Our Ref: R/257/13/

**Town & Country Planning Act 1990 (as amended)
Town and Country Planning (Development Management Procedure) (England) Order 2010 (as amended)
Application for Full Planning Permission**

Development Change of use from B1 (Business) to a dog day care centre & boarding facility (Sui Generis)
Location Unit 2, Phoenix Terrace Artex Avenue Rustington

Proposed Ground Floor Plan 1:100  
Rev A  
Prepared for Arun District Council  
January 2014

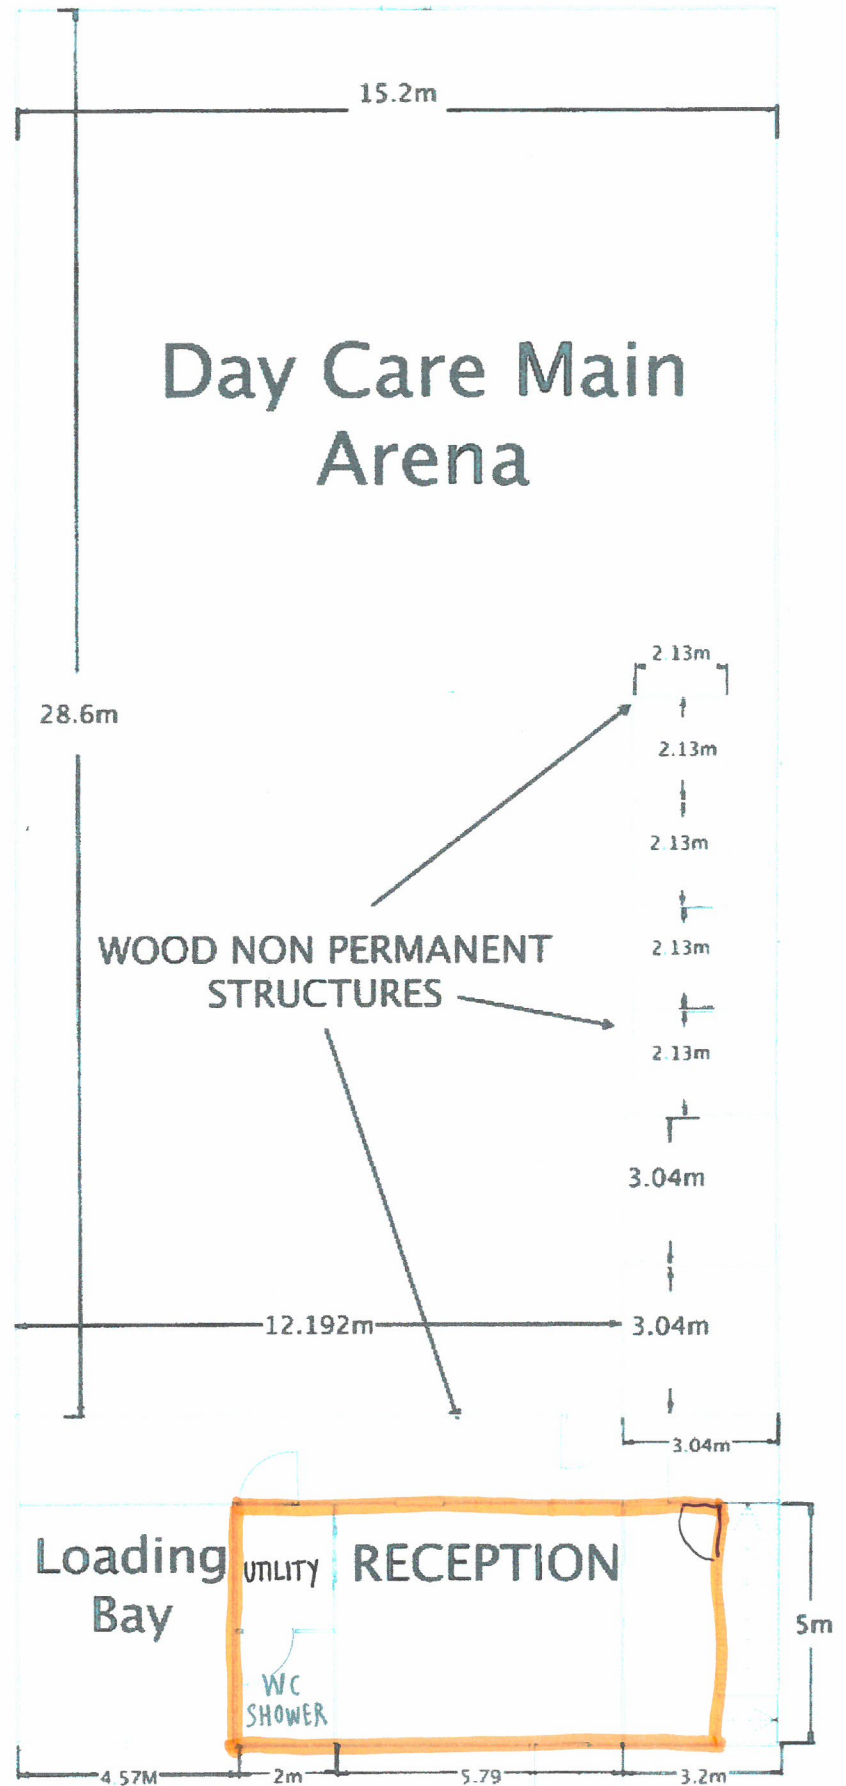
We require a floor plan of what the unit was before. If you made no changes to the inside then please forward amended plans titled existing & proposed. If however you erected the non-permanent wood structures and other areas, we require a plan of what the unit looked like before
